Rivenhall Integrated Waste Management Facility (IWWMF)

Relevant Representation

19 February 2023

Rivenhall IWMF DCO Preliminary Environmental Information Report Noise response

Figure 8.1: Sensitive Receptor Locations identified in Condition 38

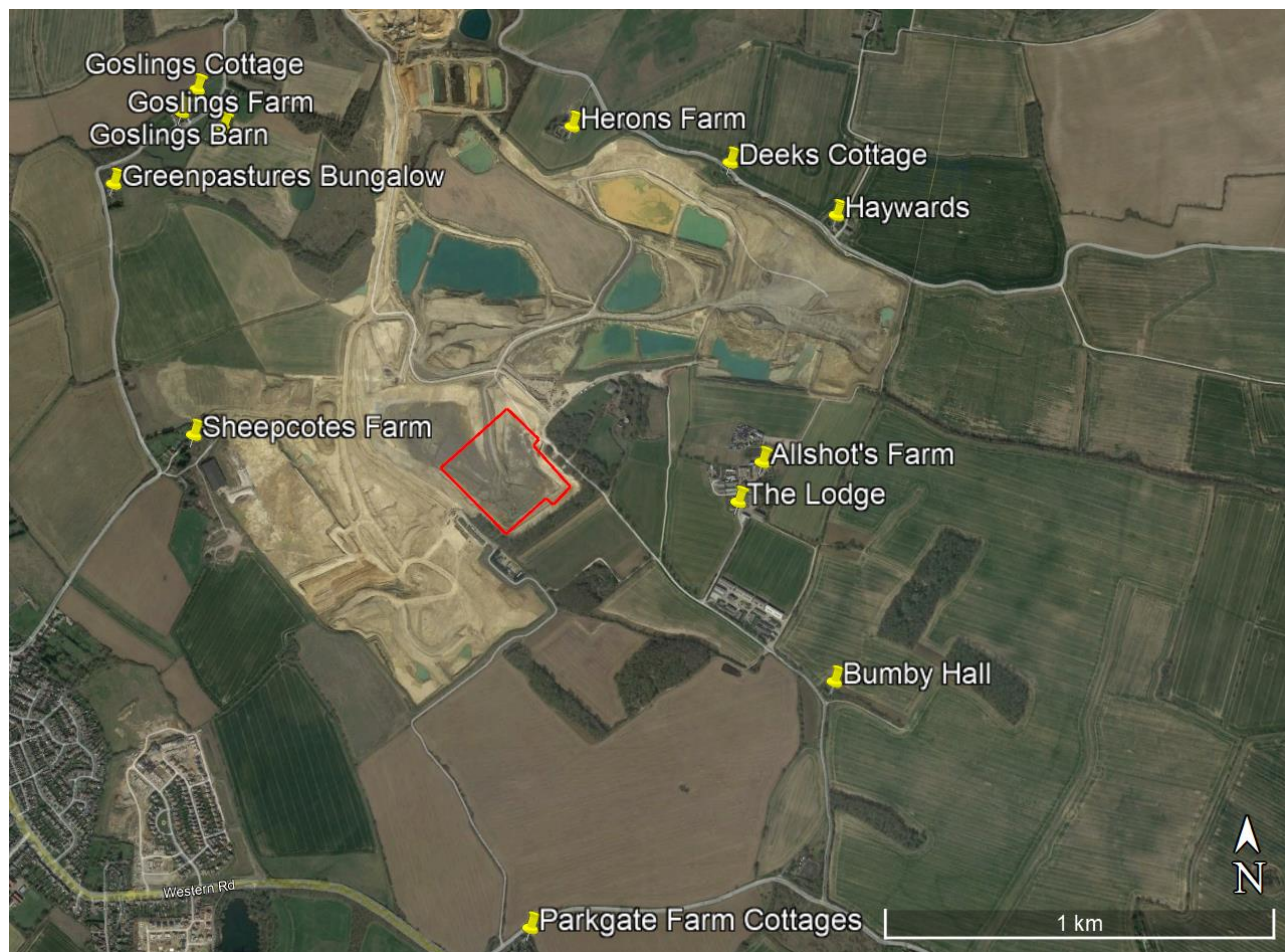
Also under 'Establishing Baseline Scenarios', the chapter presents the current planning conditions (Conditions 38, 39 and 40), concluding in 8.4.18 that these will be used for the basis of the assessment for the proposed development (note BDC and ECC concerns within the Scoping Opinion to this approach, highlighted earlier). Firstly, reference is made to comments above with regard to demonstrating the suitability of using historic noise measurements for the basis of establishing noise limits. Secondly, it would be expected that the ES robustly demonstrate that the use of the current noise limits remains valid. In particular, reference should be made to BS4142:2014+A1:2019, given this is recognised as the appropriate guidance when considering the noise effects of industrial facilities on residential premises.

We would agree with BDC that relying on extant planning conditions as a basis for determining significance is not appropriate without further consideration given to their derivation and continued suitability. It shall be noted that an assessment in line with the requirements of BS4142:2014+A1:2019 would allow the consideration of impact in accordance with the most current and relevant guidance. It would enable consideration of existing and updated baseline noise monitoring to confirm or revise proposed noise limits. In deriving such limits, the Standard allows for due consideration to be given, as appropriate, to matters such as absolute noise levels (i.e. consideration to guidance in BS 8233 and WHO), context of the sound, and characteristics of the sound.

Figure 8.2: Predicted Daytime Specific Sound Level at Grid Height of 1.5m – dB(A)

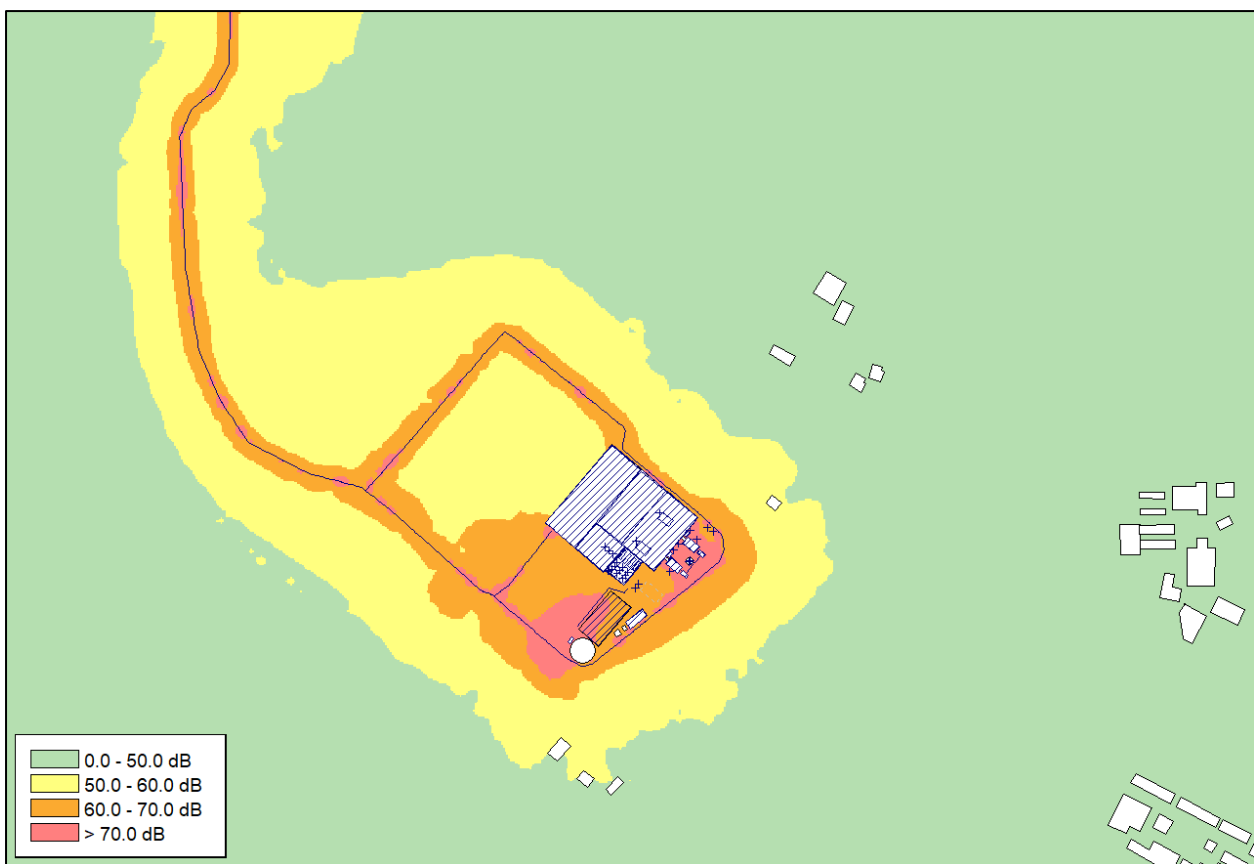
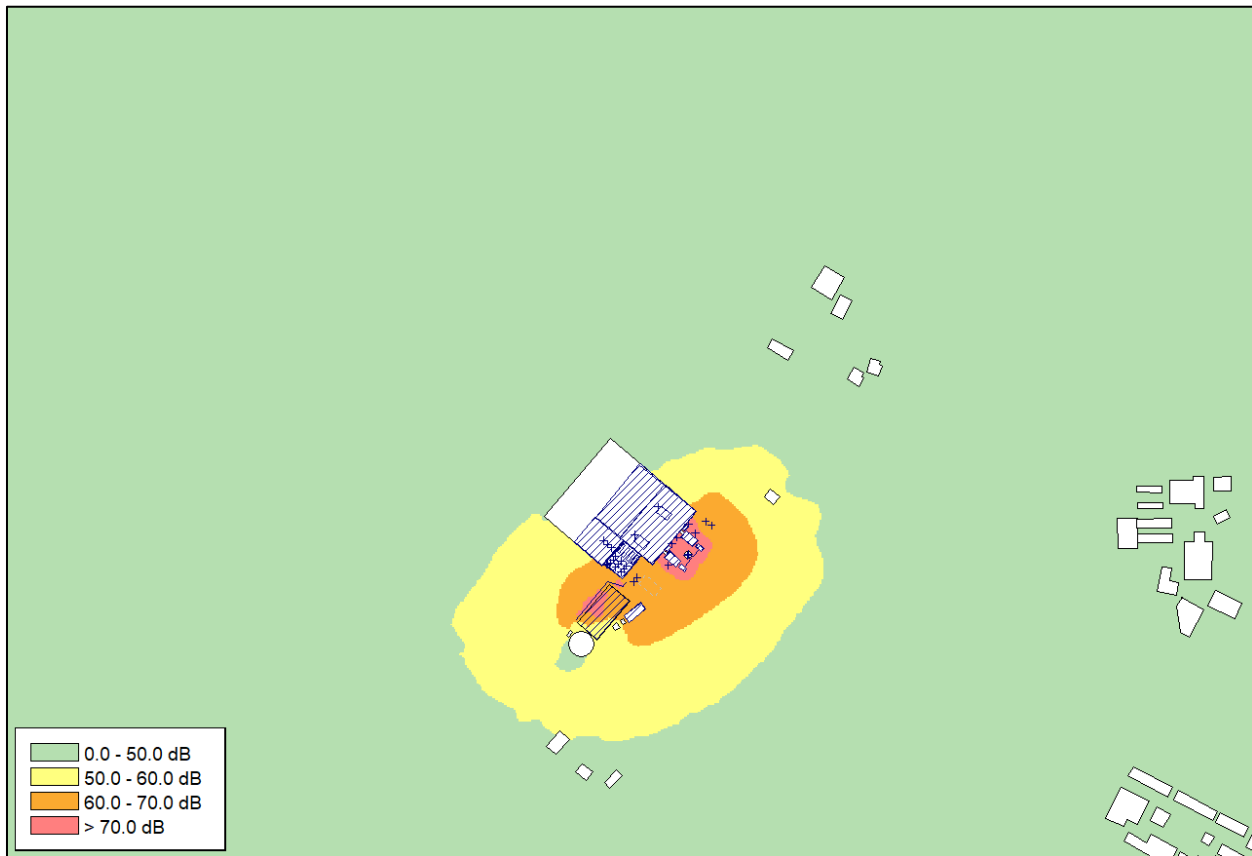
The assessment is currently based on an assessment undertaken by Belair Research Limited in 2015. It should be noted that comments provided on this assessment in 2015 and 2016 highlighted that a number of assumptions had been made within the noise modelling process that required resolution, including confirmation of various plant items. Therefore, caution should be applied to the predictions presented at this time. Notwithstanding this, and with reference to comments above with regard to reviewing assessment criteria, only once updated predictions are robustly presented, can it be determined if there is the potential for adverse impacts.
